Application Reference: 6/2017/0401/COND

Proposed development at: York House, 8 Salisbury Square, Hatfield, AL9 5AD

Proposal: Approval of details reserved by conditions 2 (materials) & 5 (bird boxes) on planning permission 6/2016/1086/FULL

Appendix 8

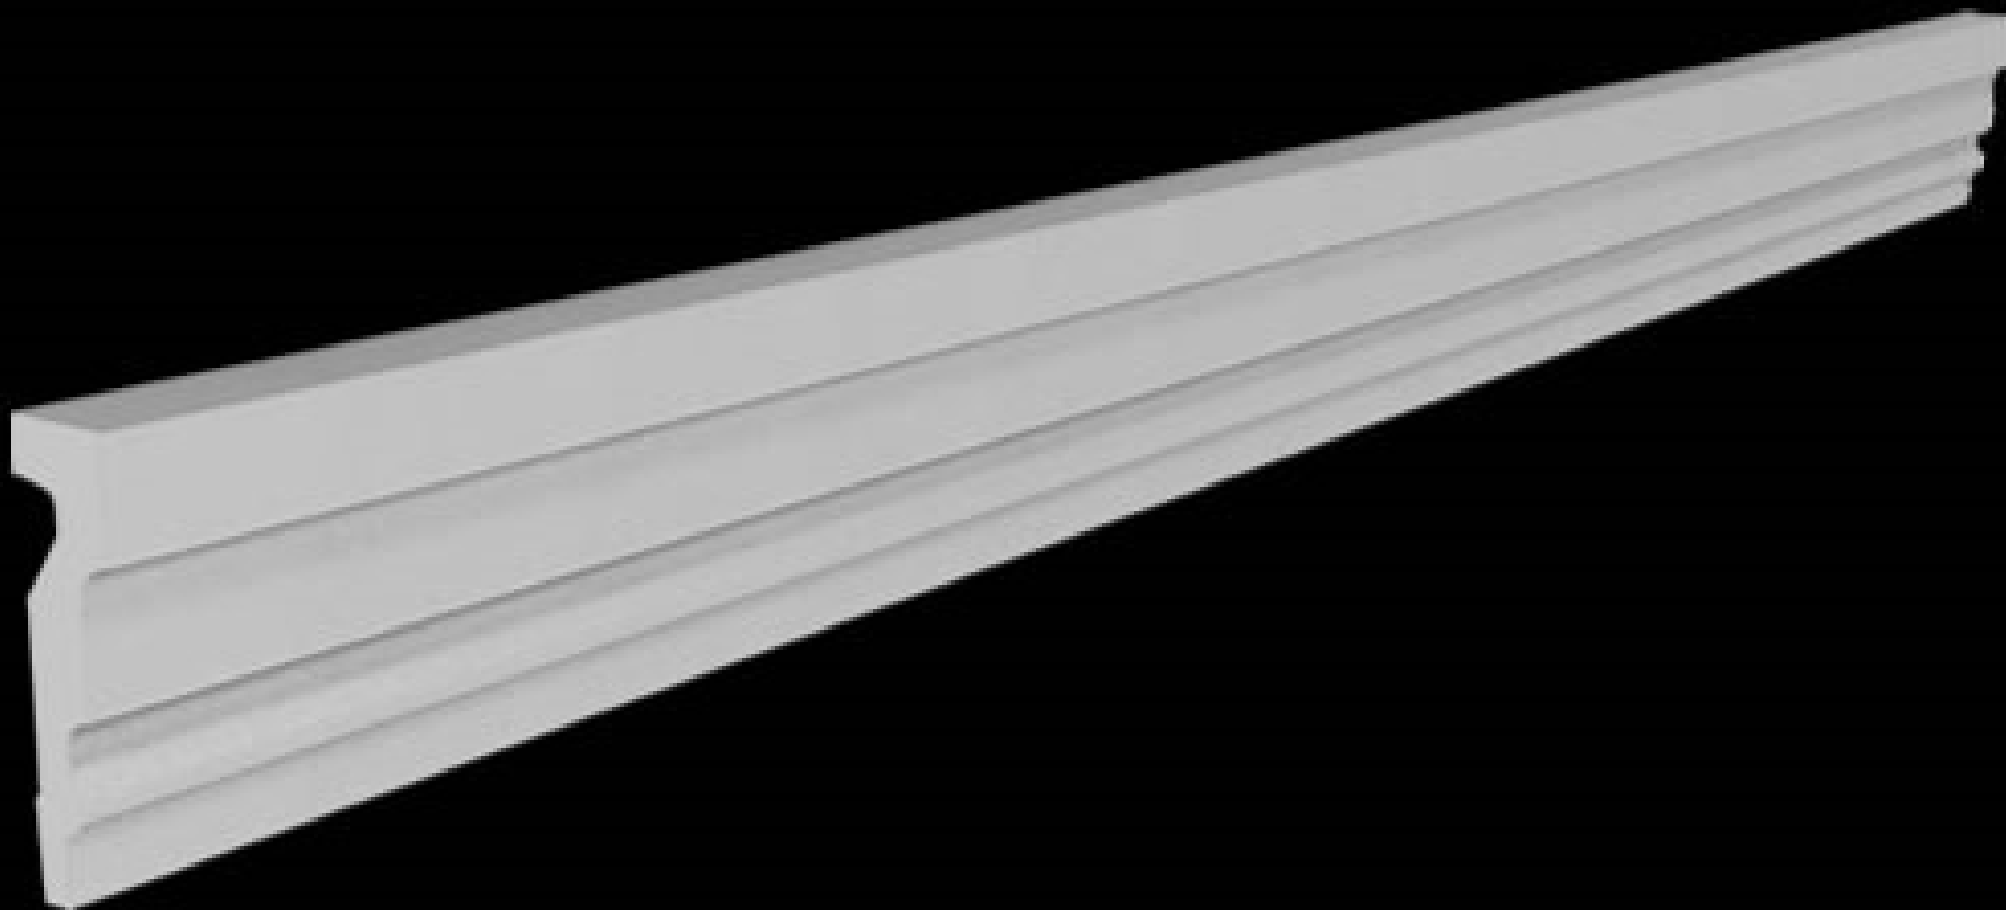
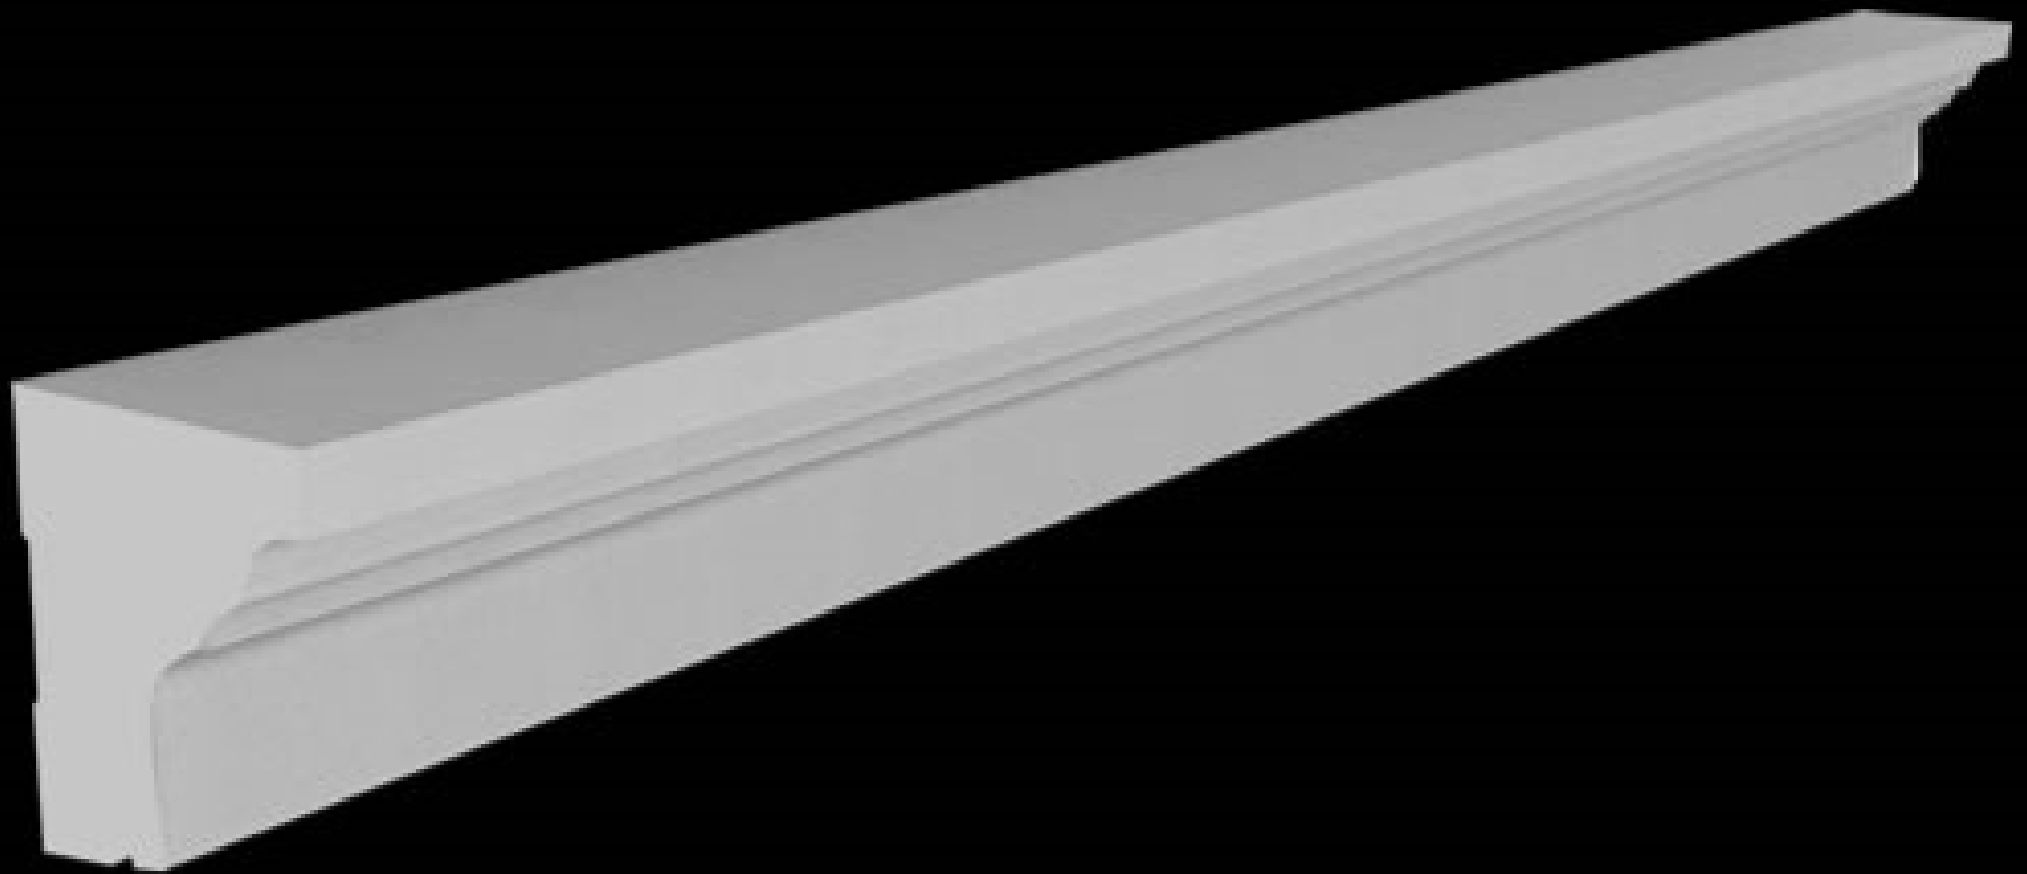
Glass Reinforced Plastic Cornice – The approval is for a sandstone finish to give the appearance of natural stone unless otherwise agreed in writing by the Local Planning Authority.

Appendix 10

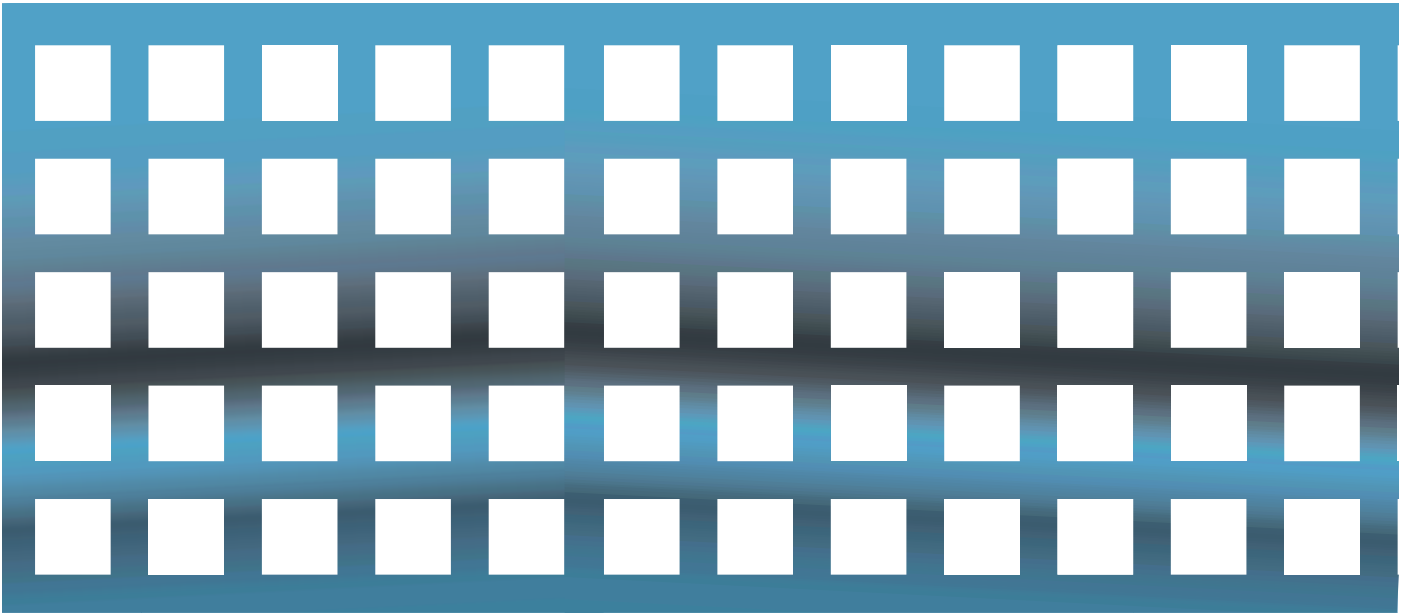
Square Perforated Steel Sheeting – This product has been omitted from the proposal. Instead facing brick and reconstituted Portland stone coping will be used to match the materials approved for use elsewhere on the building.
